## Subdivision Comments

From: Holly Erdman, Environmental Health Specialist

RE: SE-21-00017 Clear View

**CLEAR VIEW ACRES SHORT PLAT
KITITAS COUNTY SHORT PLAT NO. 06-XX
PTN. OF THE WEST 1/2 OF SEC. 1, T.19N., R.14E., W.M.
KITITAS COUNTY, WASHINGTON**

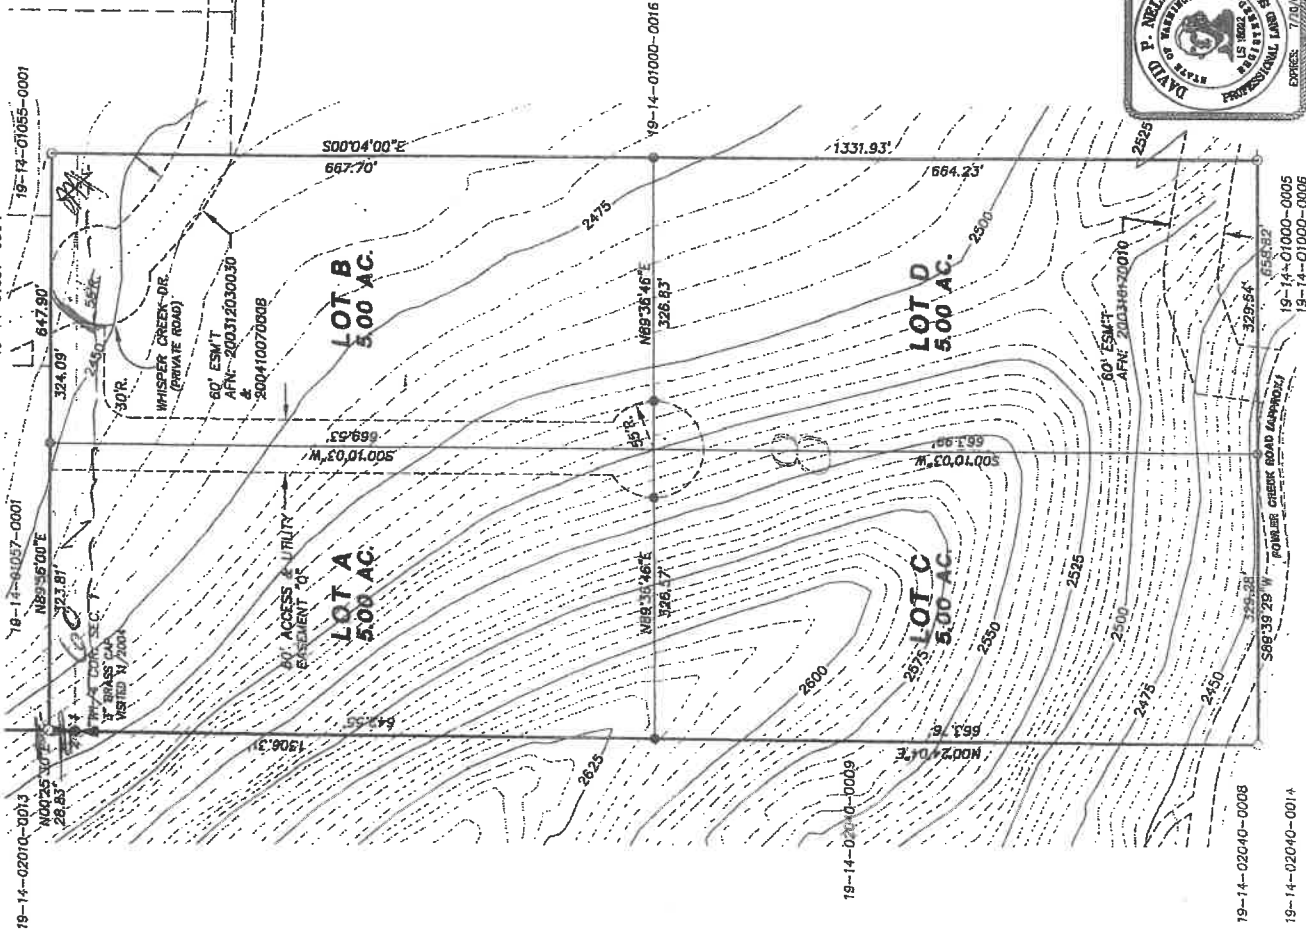
Proposed short plat indicates individual or shared wells will be used. If the intention is to utilize a shared well at any time, a signed, notarized, and filed shared well users agreement will also need to be provided before short plat is finalized. All wells must meet setbacks required in Kittitas County Code prior to final approval. The applicant must prove legal and physical availability of water for all new uses of water on proposed lots.

Please provide soil logs for each lot created.

Per KCC 16.12.030 one soil log shall be performed and information recorded for each lot within the proposed subdivision. Soil logs shall be in accordance with chapter [246-272A WAC](#).

Please provide a well log for each proposed lot. Water rights must be provided for each proposed lot. If shared wells are utilized then shared water user's agreements that have been signed, notarized and filed must be provided.
